Our Case Number: ABP-314724-22

Re: Railway (Metrolink - Estuary to Charlemont via Dublin Airport) Order [2022]
Metrolink. Estuary through Swords, Dublin Airport, Ballymun, Glasnevin and City Centre to
Charlemont, Co. Dublin

Our Ref : 18-020.048.docx
Your Ref :
E-mail : r.osborne@waterman-moylan.ie
Date : 24 November 2022

**Re : Railway (Metrolink–Estuary to Charlemont via Dublin Airport) Order 2022
Earlsfort Centre Block C, Earlsfort Terrace, Dublin, D02 X668**

### Figure 14.2 Groundborne Noise from Tunnel Boring Machine Sheet 7 of 7

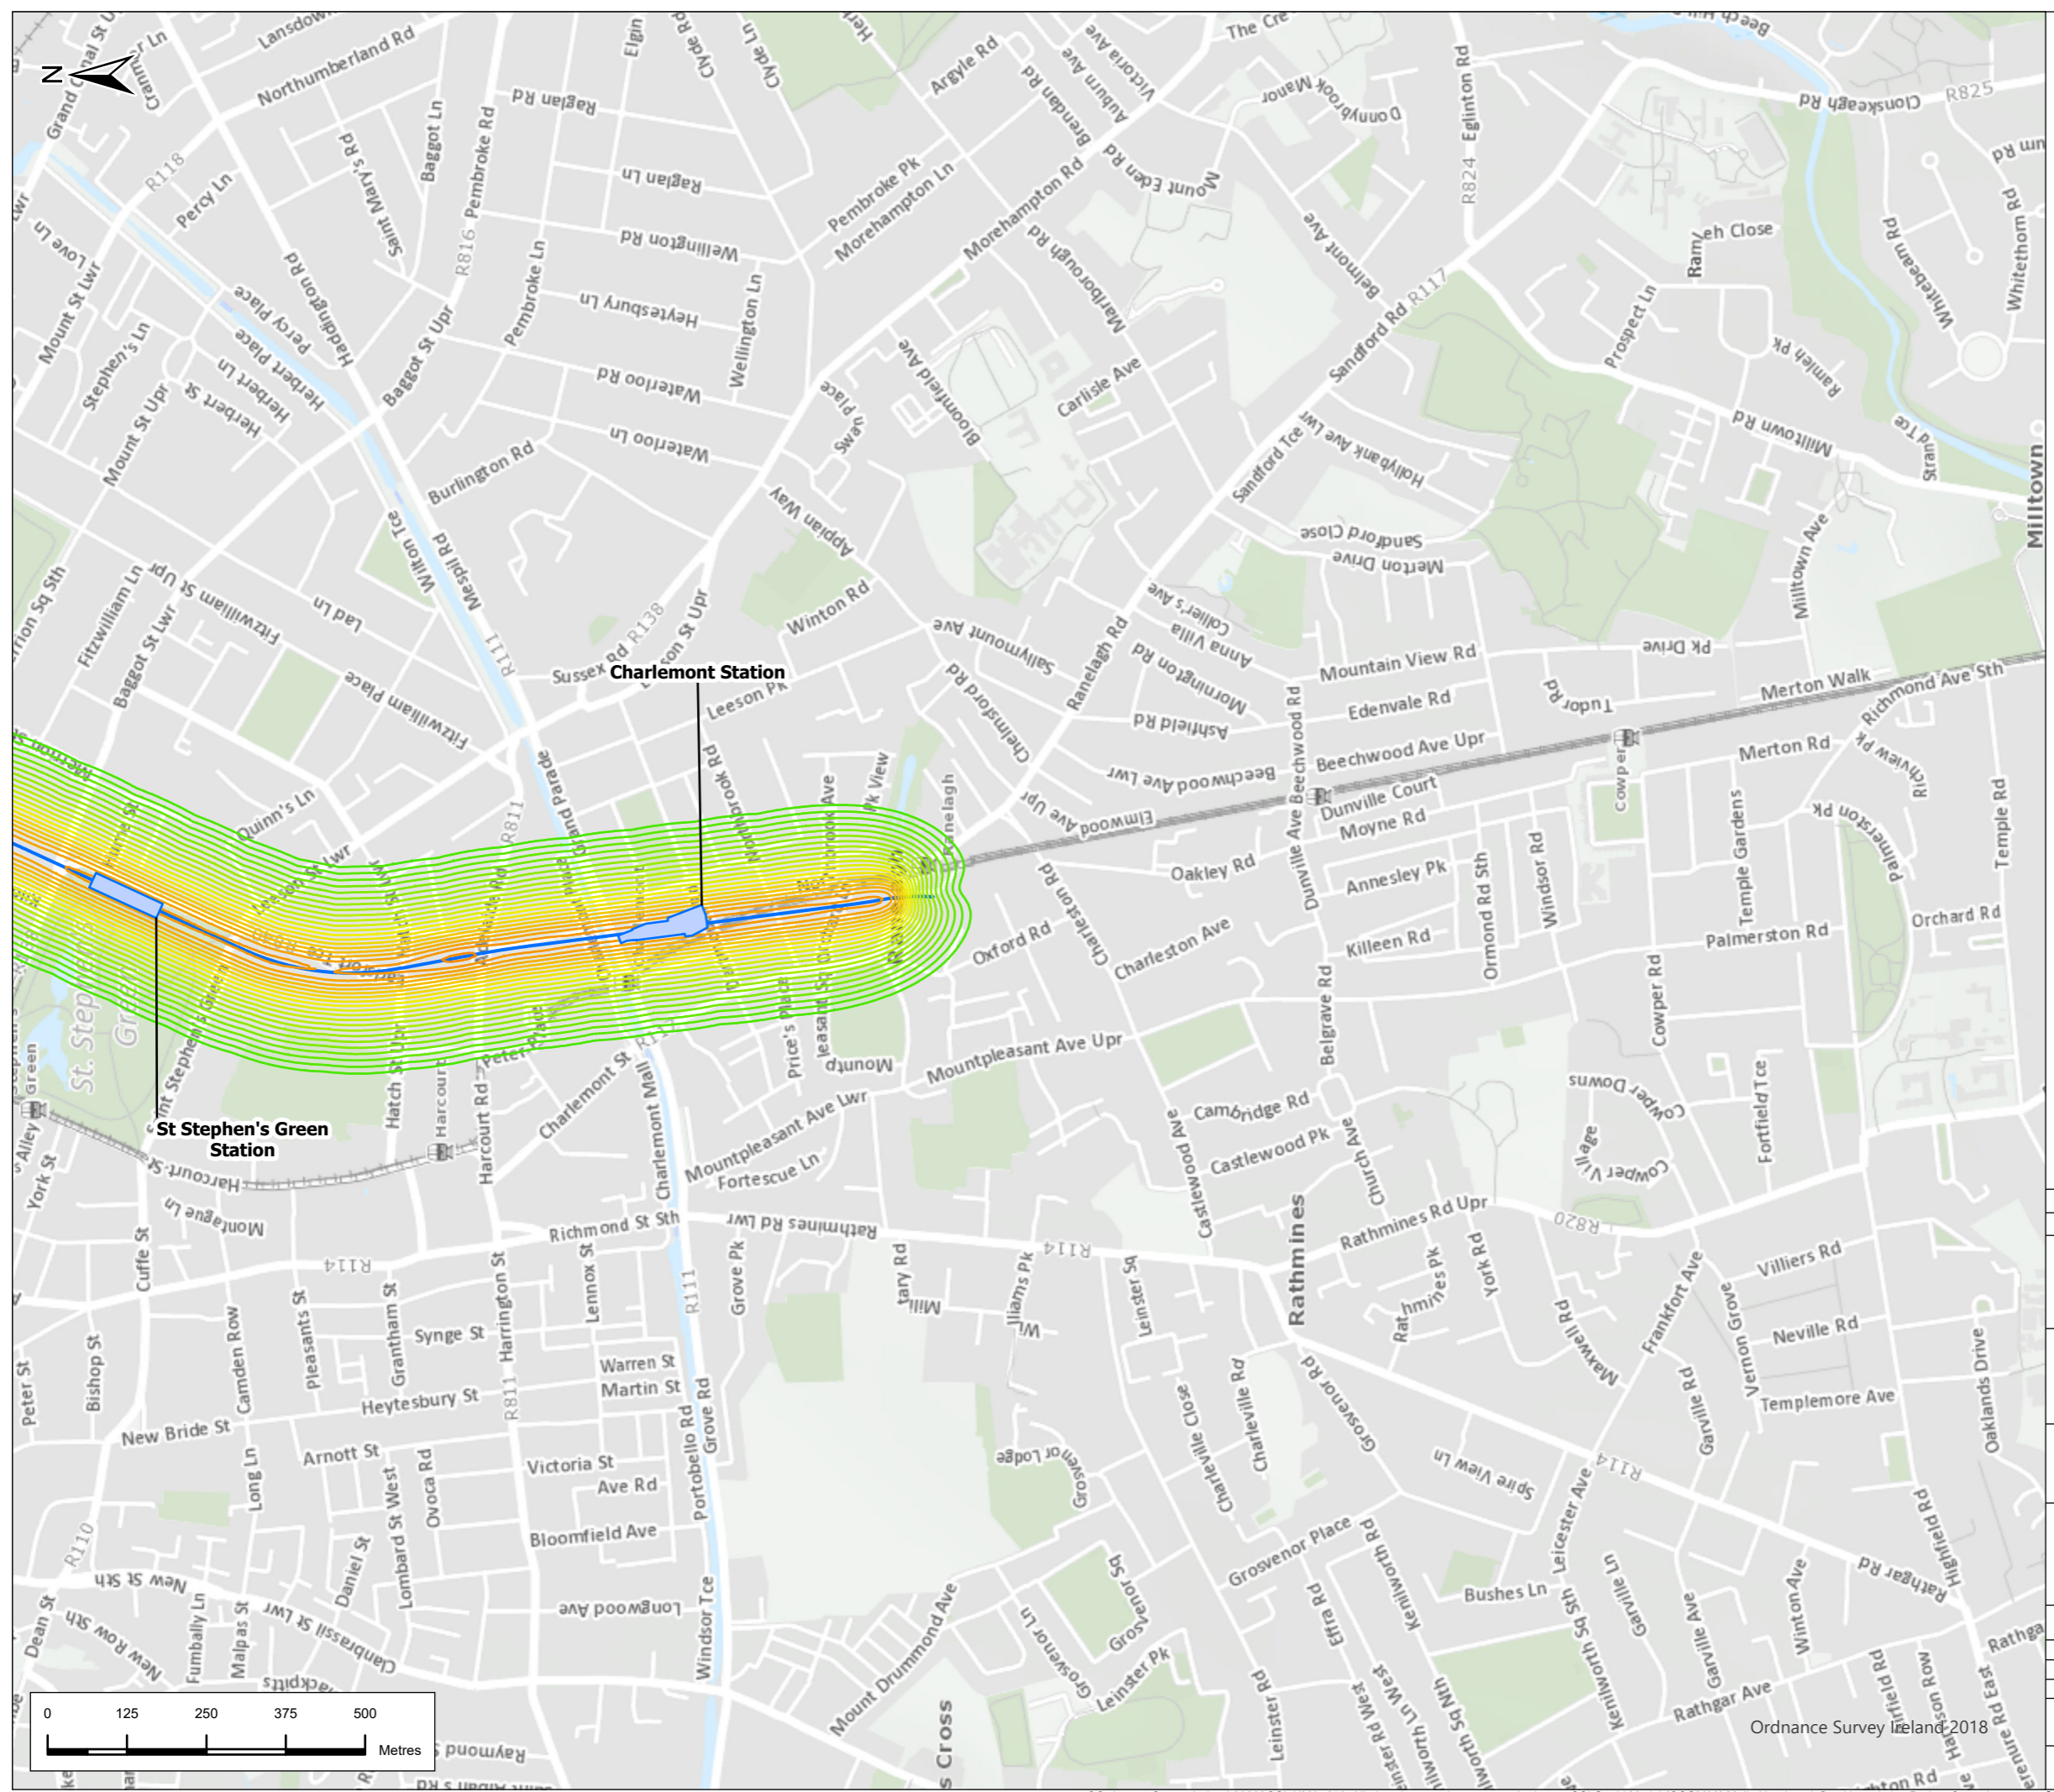
- a) Metrolink has assessed the "Groundborne Noise from Tunnel Boring Machine" and presents its findings on drawing no. ML1-JAI-EIA-ROUT-XX-DR-Y-14009 (a copy is attached to this submission). This drawing indicates MetroLink will generate an additional 50db directly under the location of our client's building which is unacceptable.
- b) Metrolink has assessed the predicted "Settlement" and presents its findings on drawing no. ML1-JAI-EIA-ROUT-XX-DR-Y-21149 (a copy is attached to this submission). This drawing indicates MetroLink will be causing a 40mm settlement directly under the location of our client's building which is unacceptable. Settlements of this magnitude cannot be accommodated by the building's structure and will cause damage to foundations; basement; superstructure; façade and internal finishes. As

previously stated the basement structure forms the waterproof envelope to our client's building and any damage would result in the ingress of water into the basement.
